**SYDNEY
 REGIONAL
 DEVELOPMENT
 ADVISORY
 COMMITTEE**

**MAJOR PROJECT APPLICATION MP10_0105 AND DA609/2010 - RESIDENTIAL
 DEVELOPMENT AT 40 WALKER STREET, RHODES**

TURNING PATHS FOR THE PROPOSED
MIXED USE DEVELOPMENT AT WALKER
AND GAUTHORPE STREETS, RHODES

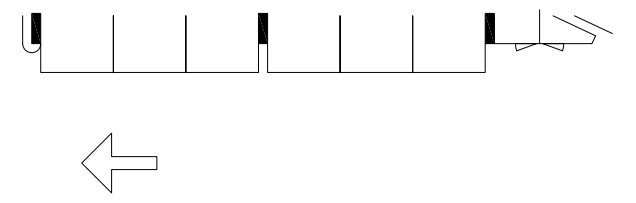
6. The swept path of the longest vehicle (including garbage trucks) entering and exiting the subject site, as well as manoeuvrability through the site, shall be in accordance with AUSTRROADS, AS 2890.1 - 2004 and AS 2890.2 – 2002. In this regard, a plan shall be submitted to Council for approval, which shows that the proposed development complies with this requirement.

7. All vehicles are to enter and leave the site in a forward direction.
8. All vehicles should be wholly contained on site before being required to stop.
